Shivesh Singh - Online Submission from Mark Adams of Private (object)

Submission for Job: #3779 MP10_0016 - Project Application for Seniors Housing and Care Facility
https://majorprojects.onhiive.com/index.pl?action=view__job&id=3779

Site: #2200 Scottish Hospital, 2 Cooper St, Paddington
https://majorprojects.onhiive.com/index.pl?action=view__site&id=2200

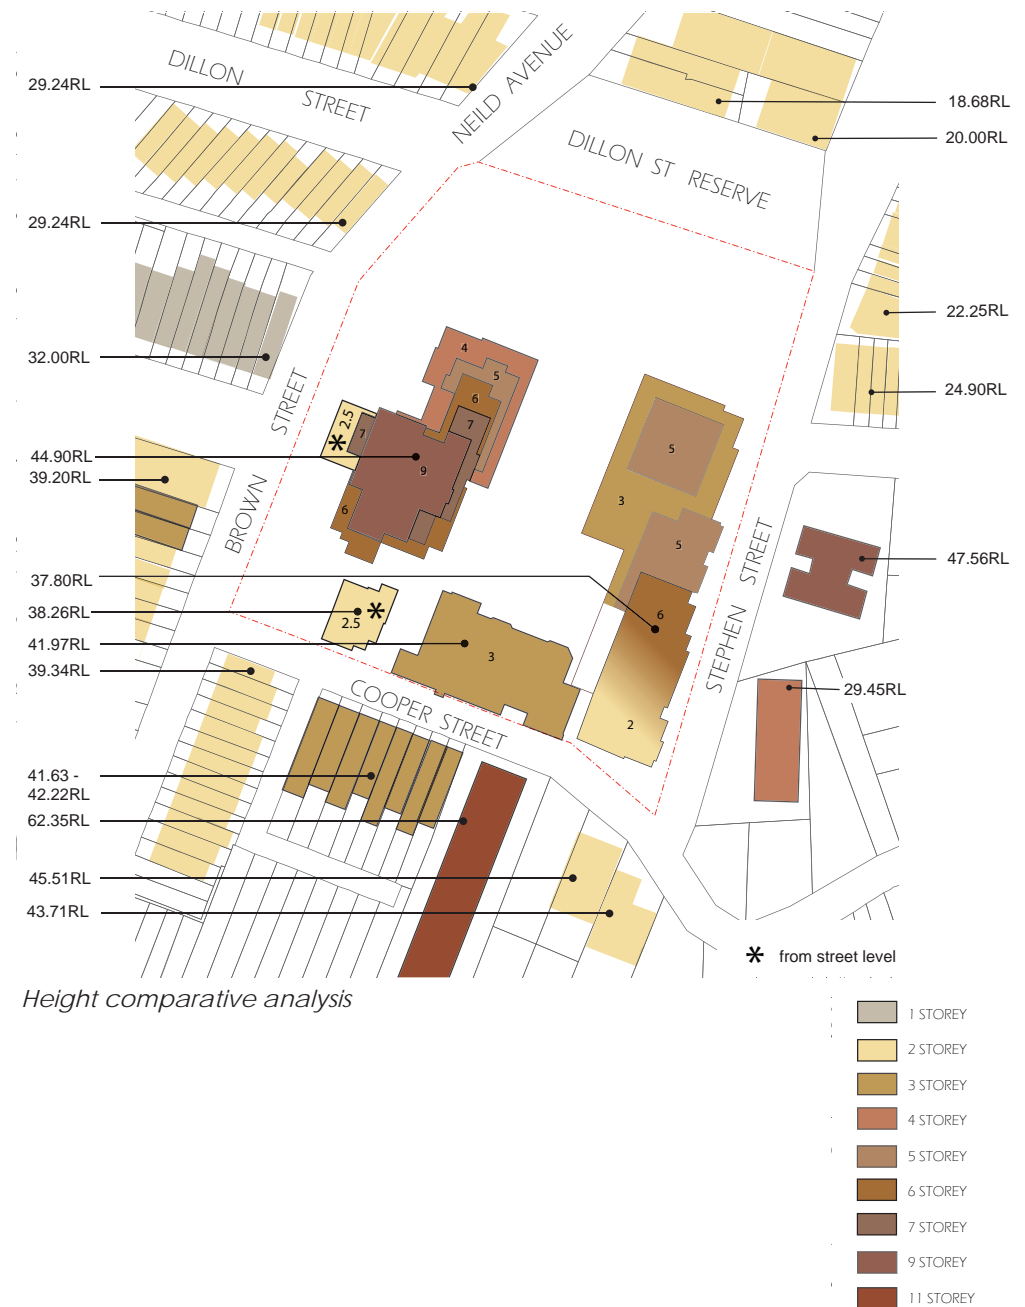
2. The Urban Design Report makes comparison between the new development and the existing built form in the area. The figure on Page 41 of this report is conveniently presented in terms of Reduced Level and not height. Given the sharply sloping topography in the area this misrepresents the scale / bulk of the proposed buildings down slope. The report also makes significant comparison with the existing 60's / 70's buildings on Stephen and Cooper Street. Such precedent should not be considered in planning matters.
